10May 2017

Re: Western Sydney Stadium - Response to Stage 2 DA Comments
Attachment One – detailed Comments
'Landscape & Public Domain

Council has reviewed the Landscape Drawings prepared by Aspect and raise the following key concerns with the proposed design.

O'Connell Place - Everyday Mode

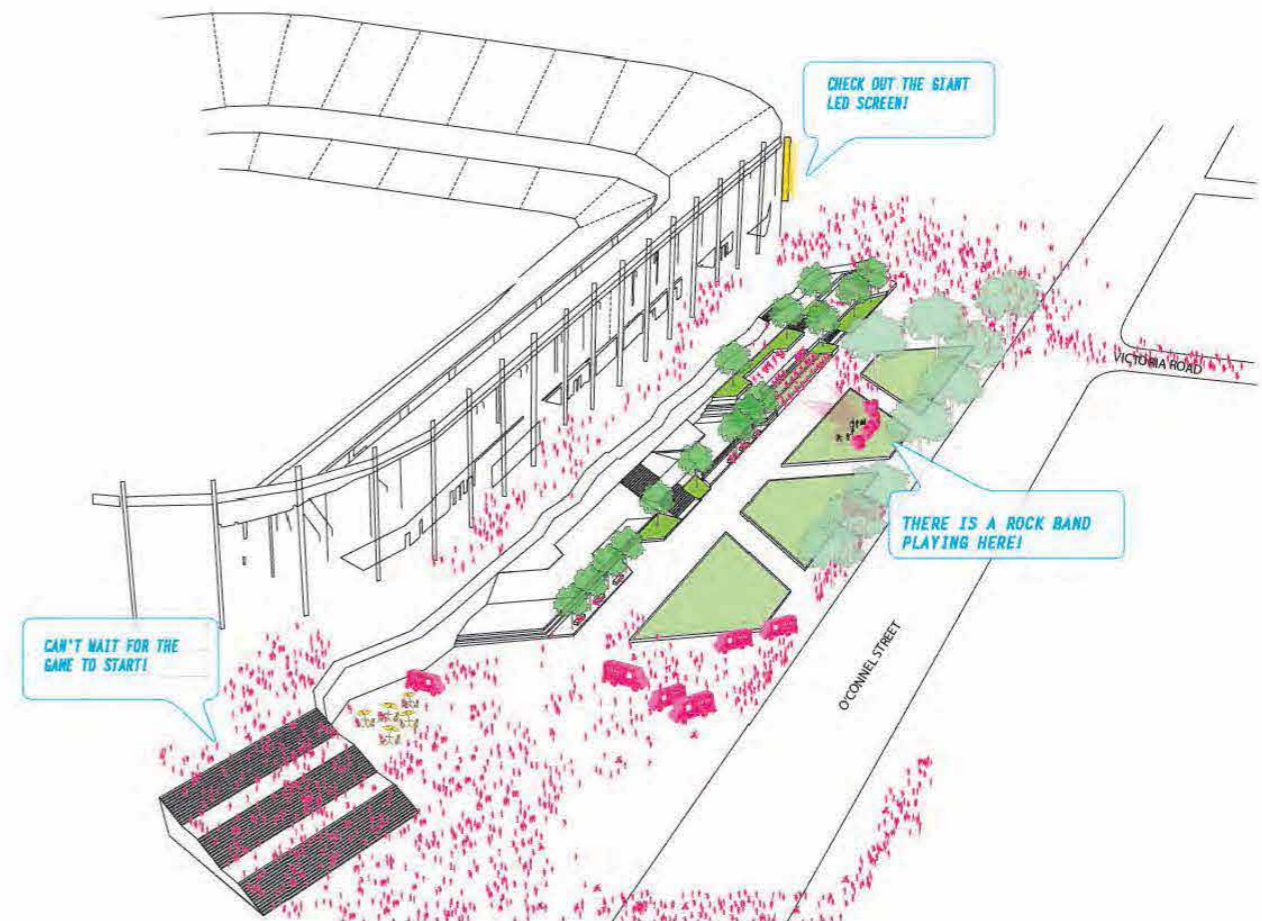
Lawns at O'Connell Street will be subject to significant use, especially during the winter overshadowing, and may not recover sufficiently after each event. This feature could become a maintenance issue for the operators in the future. As detailed in this submission, the lawn area should form part of an integrated activated public domain.

· Reconsider inclusion of lawns at O'Connell Street with paved areas, integrated multiuse sport courts and other dynamic uses that make this space a 'destination'.

The design of the O'Connell Street forecourt area has been revised to include multi-use half courts, and a terraced area including children's play opportunities.

The children's playground area is envisaged to include to a variety of play elements including, slides, climbing nets, sloped climbing walls, appropriate playground style trampolines, and spinners. These elements will be integrated with the terracing to create a variety of play opportunities and experiences for children across a range of ages, and to minimise the impact of the level change from concourse to plaza. Low steps and bench seating provide places for parents and children to rest and watch the play.

Accompanying these active areas within O'Connell Place is an amphitheatre area with a combination of low grass terraces with integrated seating edges. Both areas provided opportunities for visitors and workers from the stadium to rest, picnic and observe the passing parade, while the amphitheatre could also be activated for small performances.

River Terraces - Everyday Mode

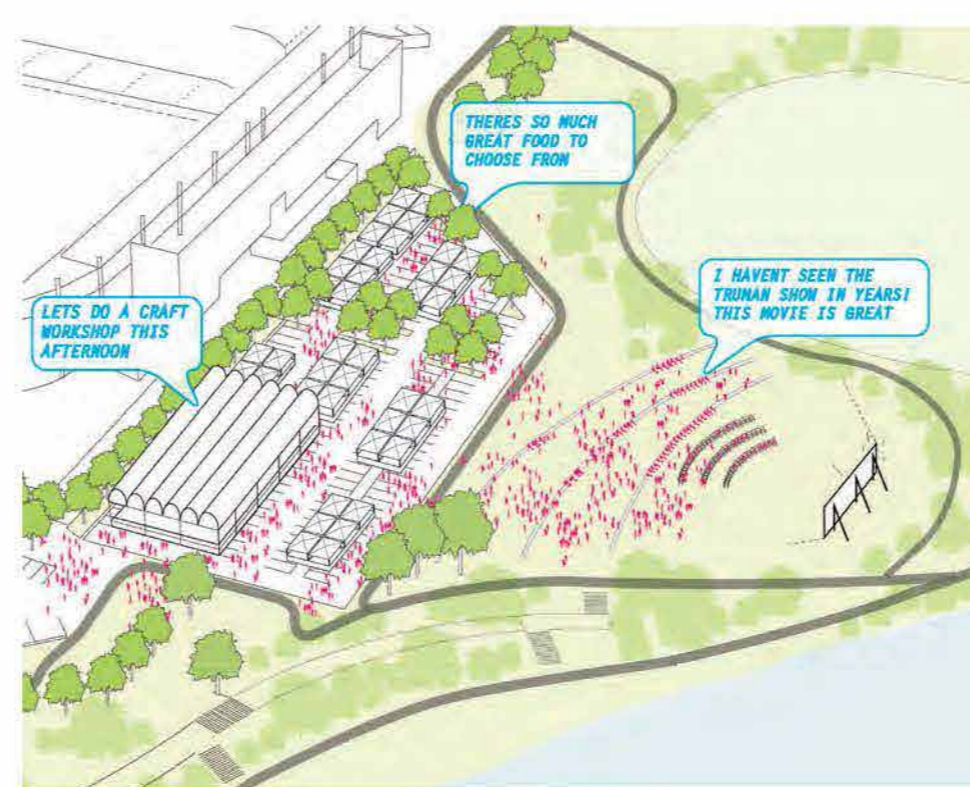
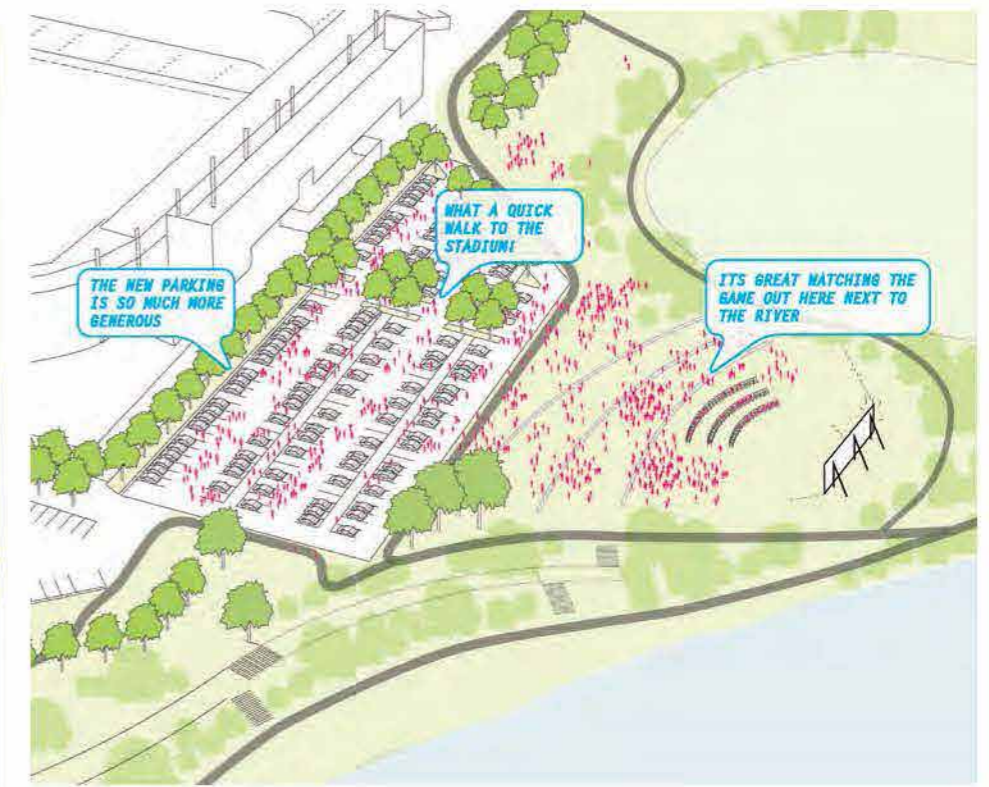
Council is concerned that the River Terrace is visually isolated from O'Connell Street and it is not clear if it is seeking approval as part of this application, or if it will be publically accessible at all times. Due to the poor connectivity and visibility to this precinct from the south-east (City and River foreshore), where

no continuous pedestrian paths from O'Connell Street to the western edge of the stadium is provided, it is unlikely that visitors will 'wander' across this space and casually gather for an event without prior notice/planning. Council would like to see this area as part of the public domain and designed integration with the foreshore access to the public, and opportunities to link both with events days and non-event days.
